These drawings are for a non-material amendment application to the previously approved design, reference '22/1164/FFFU'. Changes annotated on the drawings & are as follows:

Project Address
24 Park Avenue, Camberley, GU15 2NG

Sheet Title
Elevations - Proposed GA (Sheet 2)

Sheet Ref.	MAP-C4813-132	Rev.	0
Project Ref.	C4813	Date	14.02.2024
Drawn by	FM	Checked by	JMS
Scale	1 : 100	Sheet Size	A1

Sheet Title
Plans - Second Level - Proposed GA

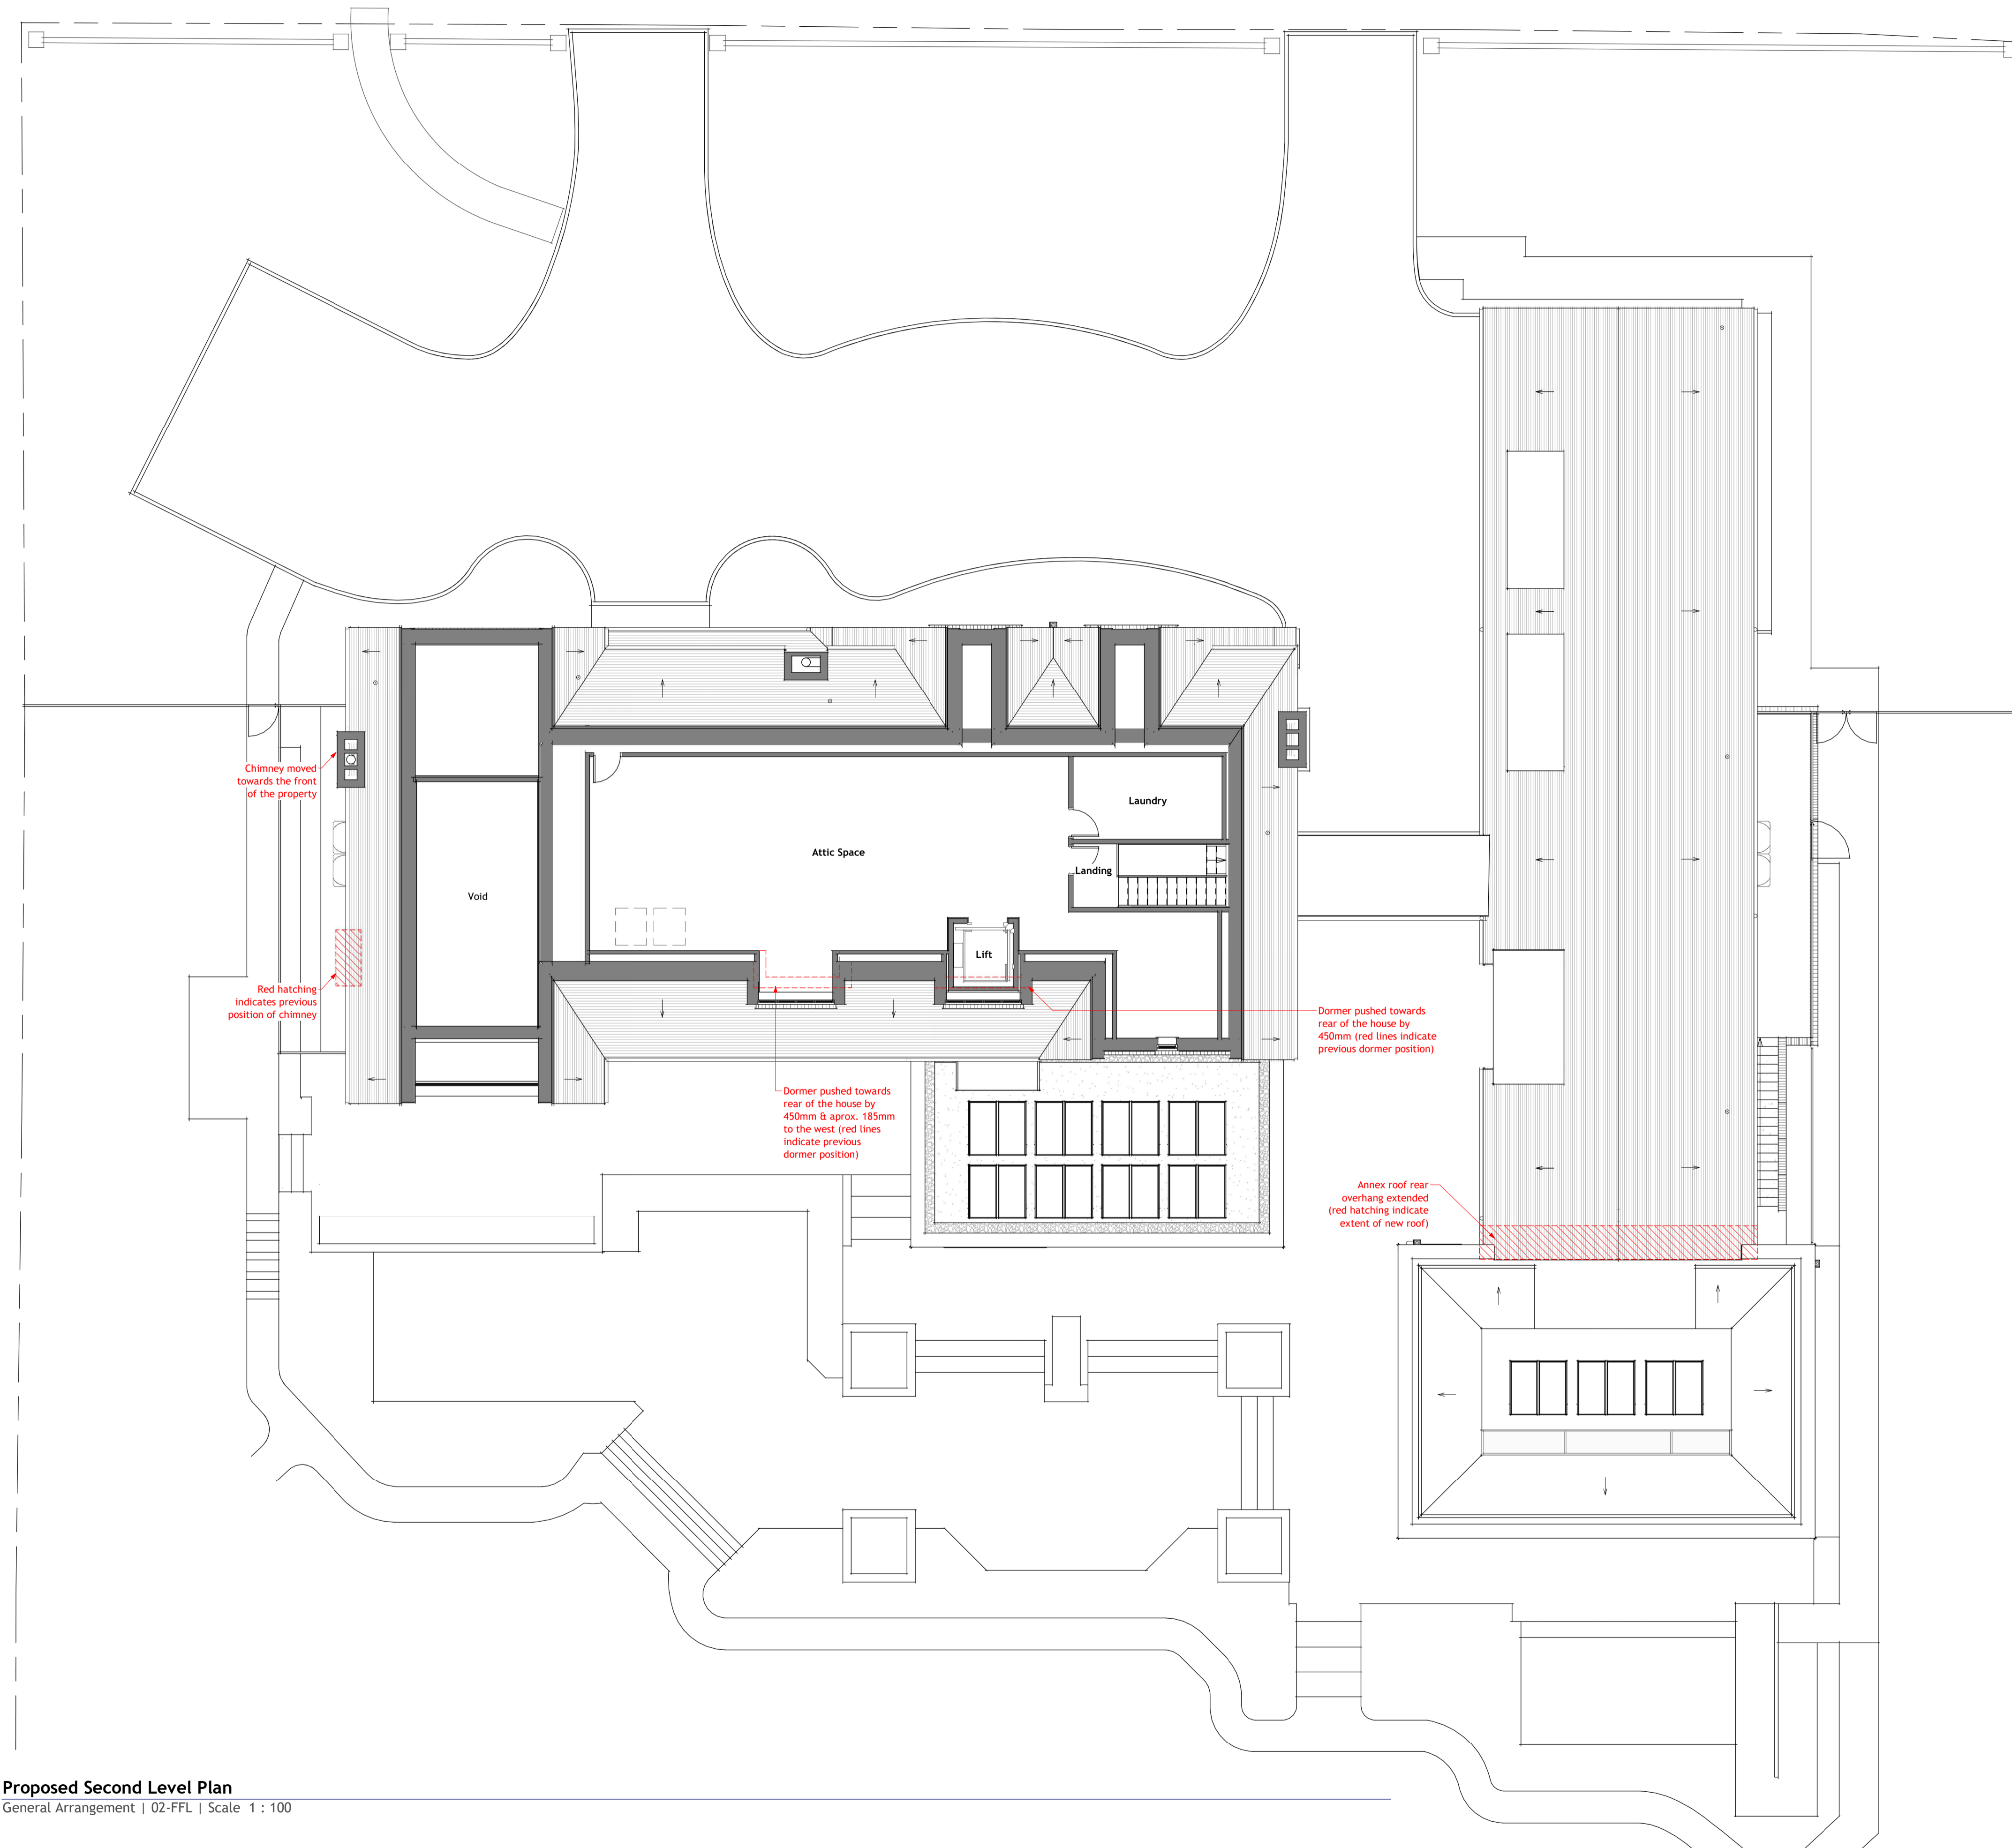
1. Windows size & position revised as shown on plans & elevations
2. Windows removed as shown on plans & elevations
3. New window in the east elevation of the house
4. West chimney moved towards the front of the house as shown on plans & elevations
5. Dormer windows position adjusted as shown on plans & elevations
6. House roof eaves raised & roof pitch reduced by 1No. degree as shown on elevations
7. 2No. rooflights added as shown on plans & elevations
8. Glass roof removed as shown on plans
9. Annex roof rear overhang extended as shown on plans & elevations
10. Annex East wall partly rendered behind fence as shown on elevations
11. Flat rooflight added as shown on plans
